**Planning Application: Louth County Council Ref No 2560319 –
Large Scale Residential Development at Haggardstown and Marshes Upper, including works on
Blackrock Road (R172) and Hardy's Lane, Dundalk, Co Louth**

Applicant - Marina Quarter Limited

Appeal of Louth Co Co Planning File Ref No 2560319 - 07.01.2026

Drawn by: GC Date: 20.10.2025
 Checked by: BF Date: 20.10.2025
 Client: Repts of Conor Connolly (deceased)
 Project: Blackrock Road,
 Dundalk,
 Co. Louth
 Scale: 1:1000 @ A3
 Description: Follis Showing SW Pipe (Planfile 21-1032)
 Drawing No.: L-08-54-06

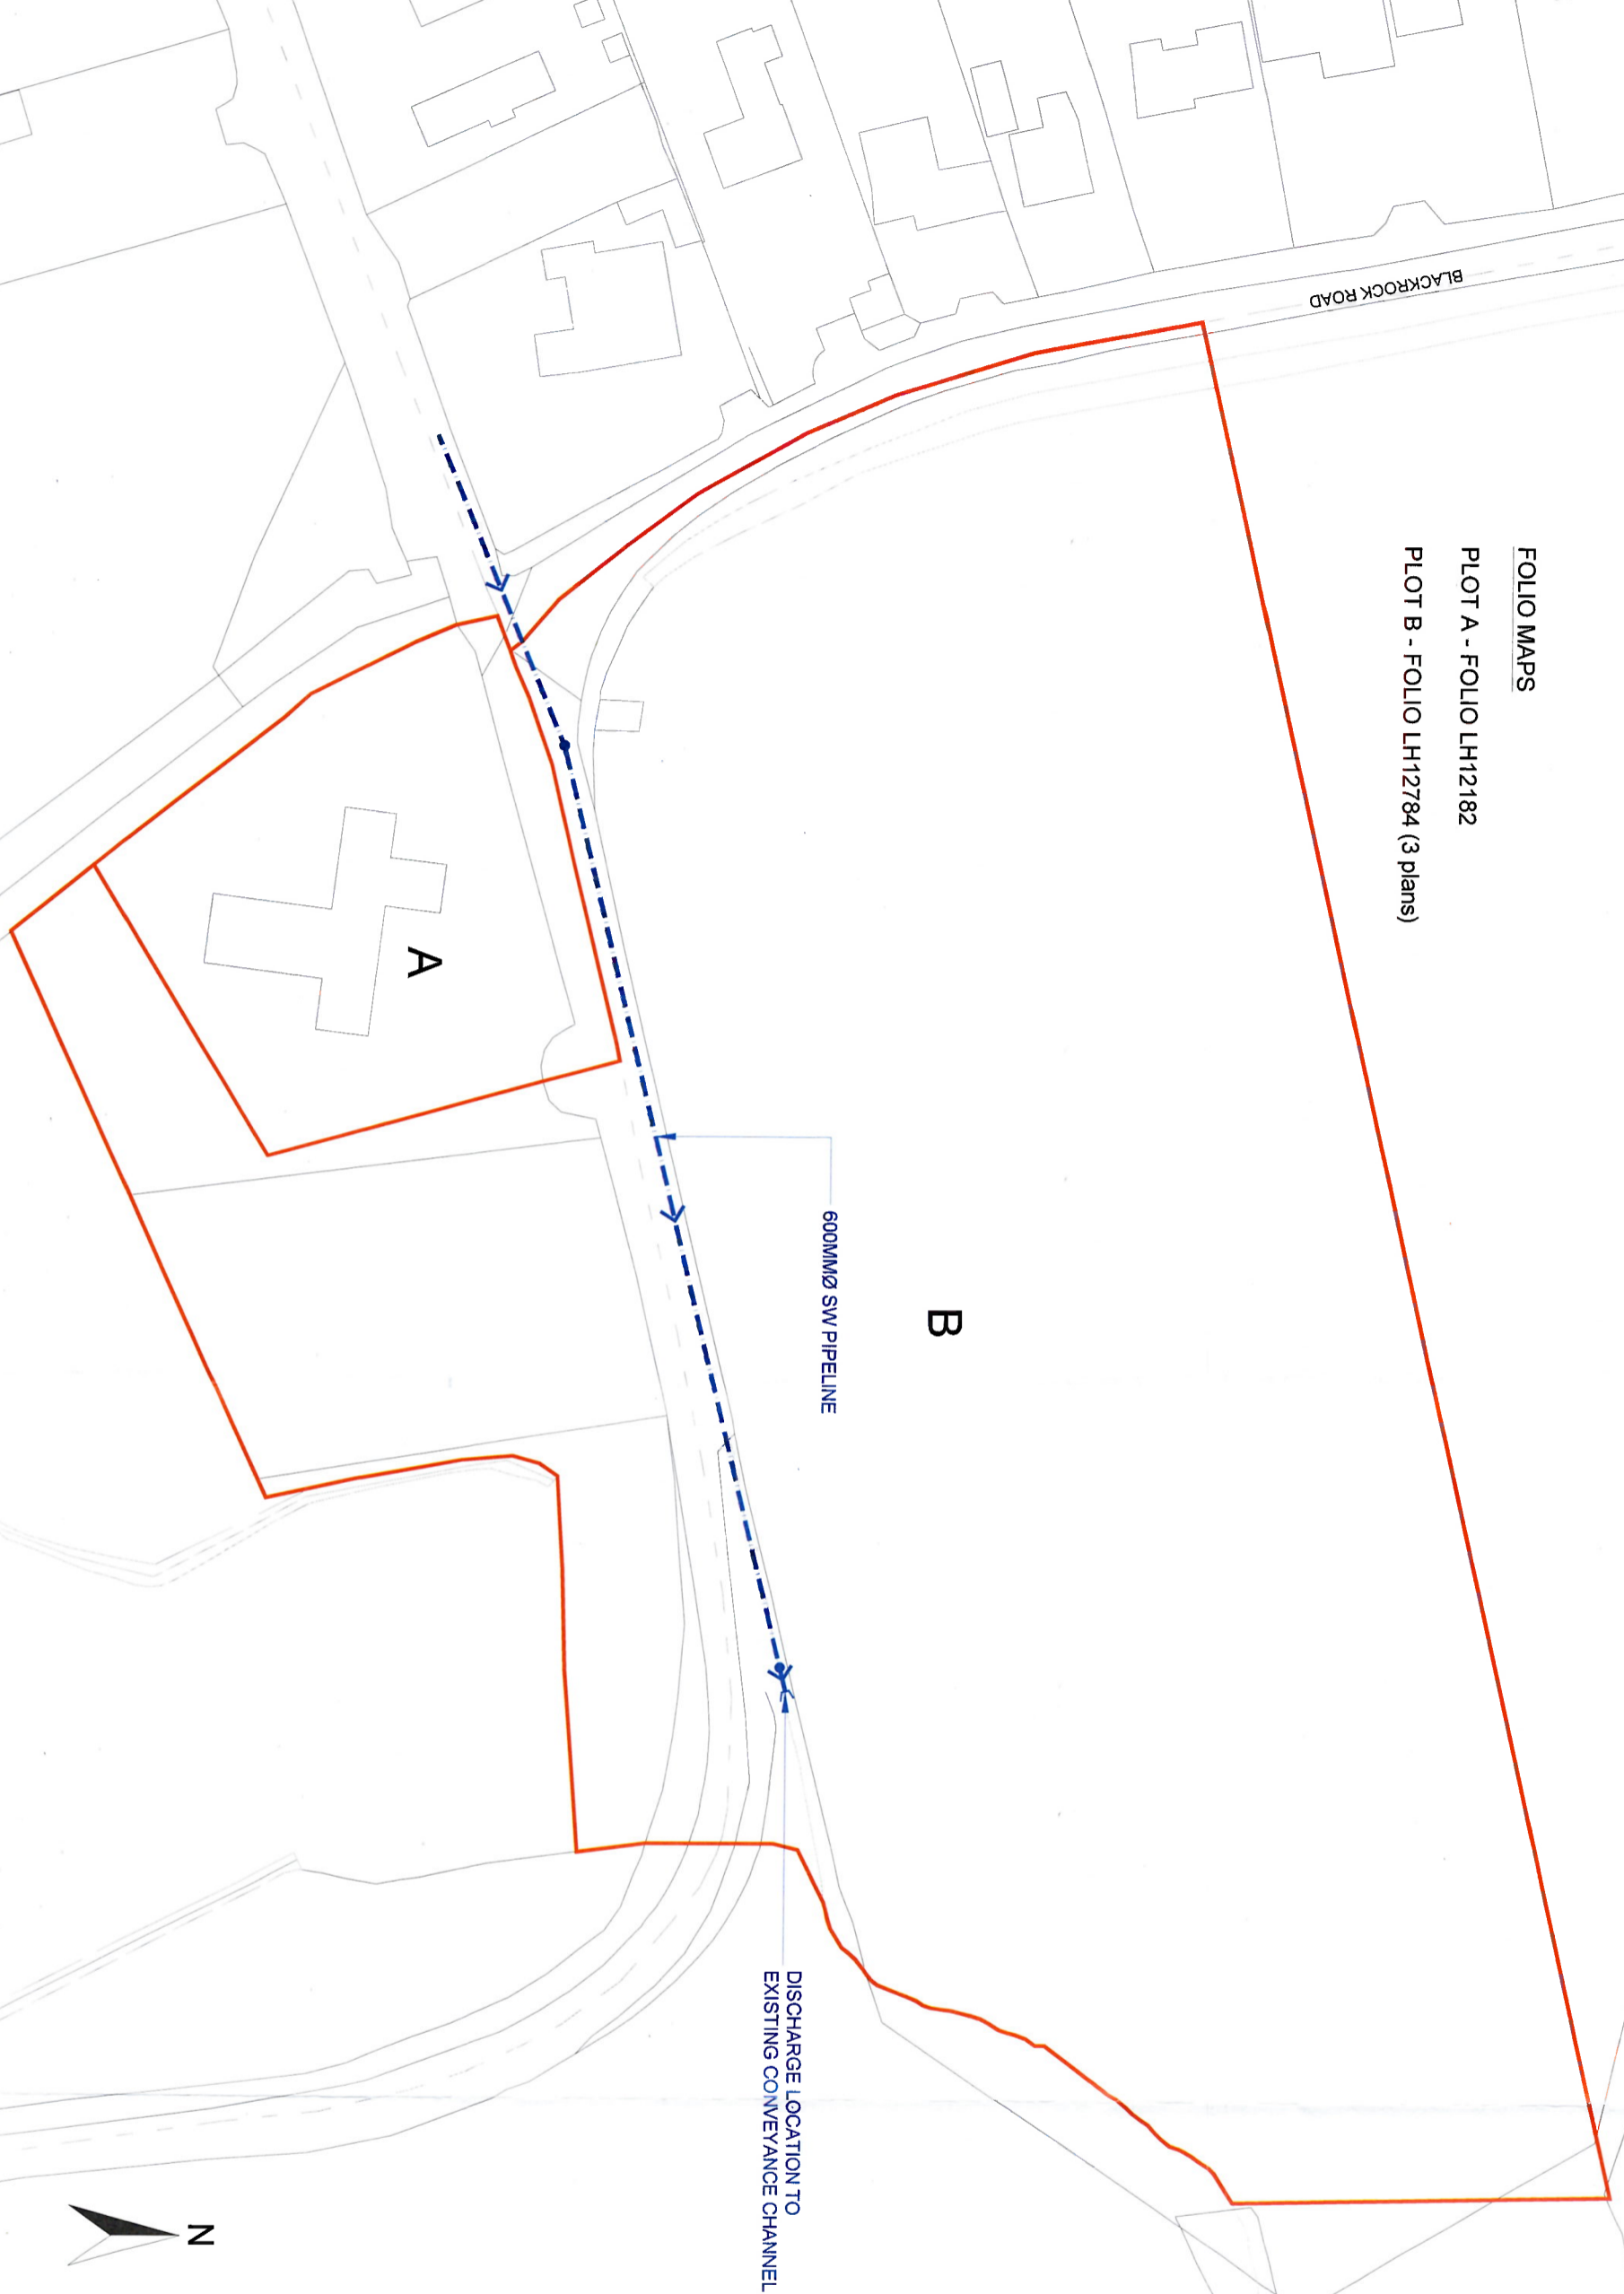
The drainage design provides for a 600mm diameter surface water sewer and outfall manhole to be constructed on our clients' lands and for the discharge of storm water generated by the proposed development to be directed into a field drain on our clients' lands. There has been no consultation of any kind with our clients on this design proposal.

This design proposal will alter the existing surface water drainage system in the area very significantly and will result in increased flooding risk to our clients' lands.

In contrast, the proposed sewer will carry all surface water collected on site from virtually the entire estate, including all 503 dwelling units and associated roads/footpaths/hard surface areas directly onto our clients' lands, greatly increasing the quantum of surface water to be dealt with in the existing field drain. It is acknowledged that the drainage system incorporates attenuation arrangements but the design will still result in c.12-fold increase in runoff onto our clients' property, a very significant increase.

However, in addition to the above, under Louth County Council planning file 211032, planning permission has been granted for disposal of further surface water drainage from a separate development adjoining Bothar Mhaol, to be directed to the same discharge point. This second discharge is separate and additional to that approved under the current 2560319 permission.

These drawings show the proposed outfall drainage arrangements are clearly proposed to be located within our clients' landholdings in each case.
